Application for a non-material amendment following a grant of planning permission.

<input type="text" value="Proposed roundabout junction"/>	
Reference number:	<input type="text" value="20/01830/F"/>
Date of decision	<input type="text" value="18/11/2020"/>

The main amendments to the proposal, following submission of the S278 application are as follows:

**A41 PIONEER ROUNDABOUT
DRAINAGE LAYOUT**

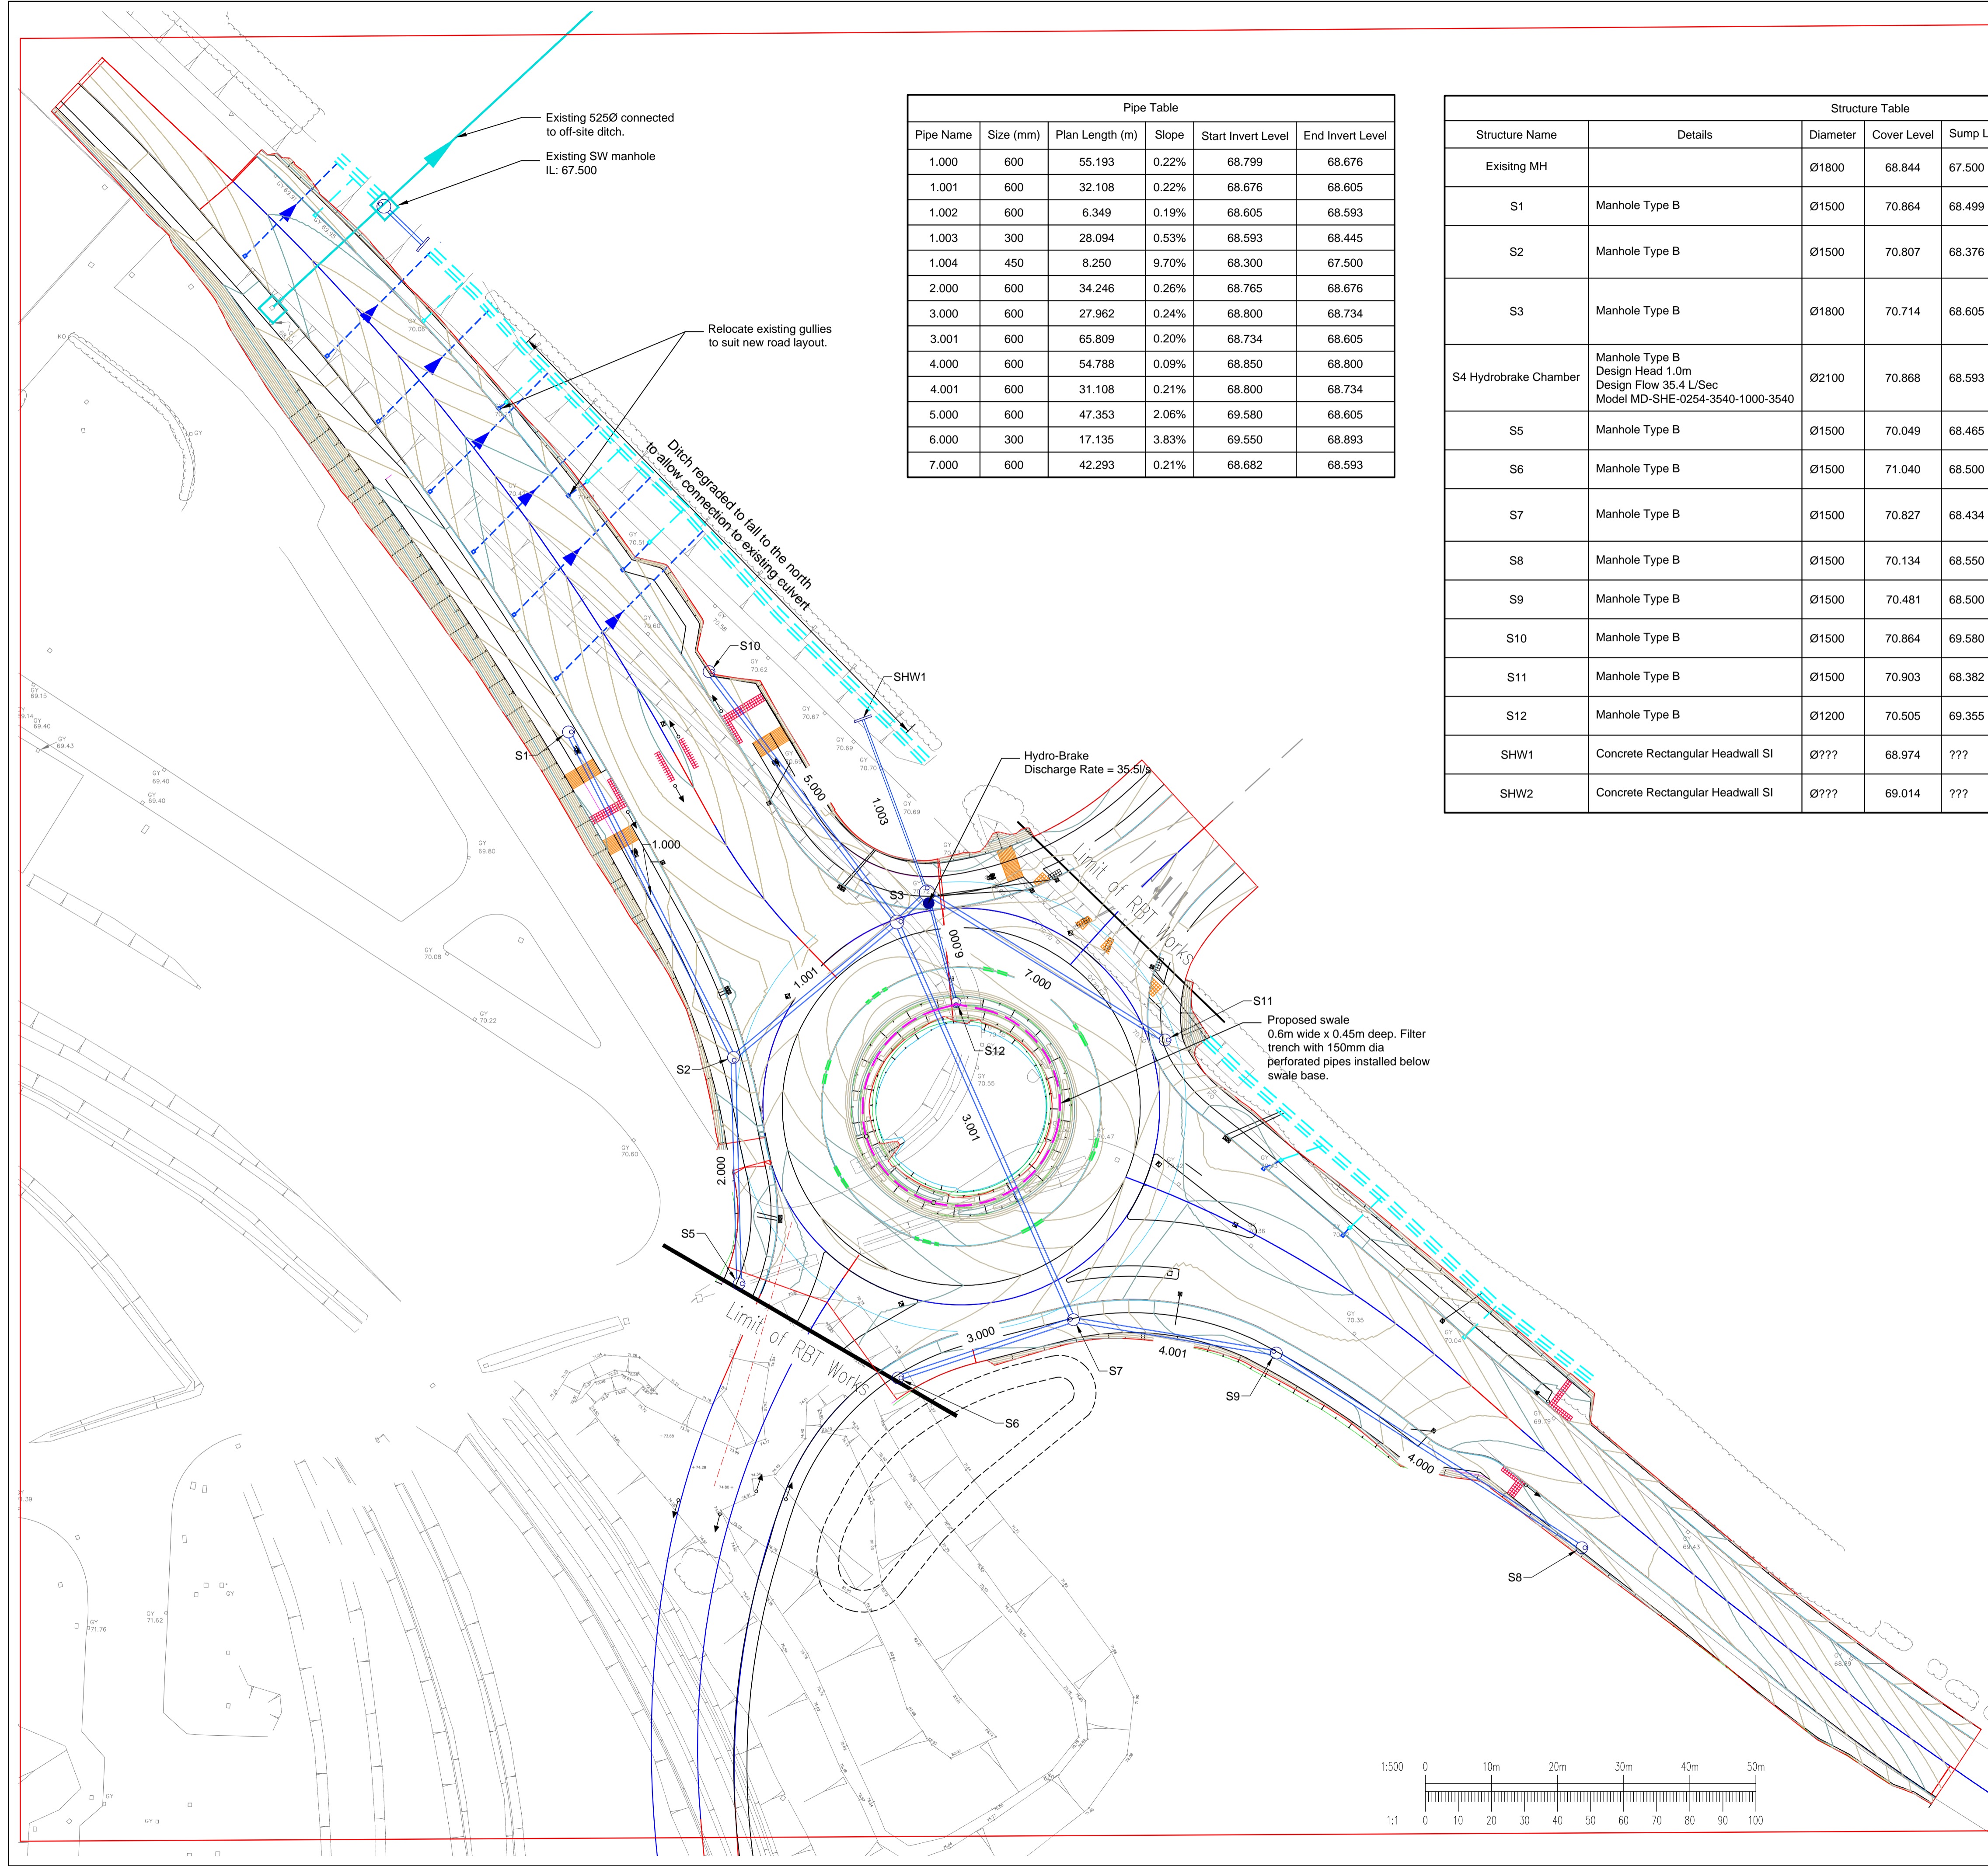
- Drainage: The previous drainage strategy included surface water attenuation within the central island of the roundabout. The attenuation has been removed and the proposals now include:

i. A swale within the central island to allow conveyance of surface water from the circulatory carriageway

ii. Oversized pipes (600mm diameter) to provide below ground storage in high rainfall events

iii. Provision of a hydrobrake to control surface water discharge to the ditch north of the A41 at agreed rates with Oxfordshire County Council
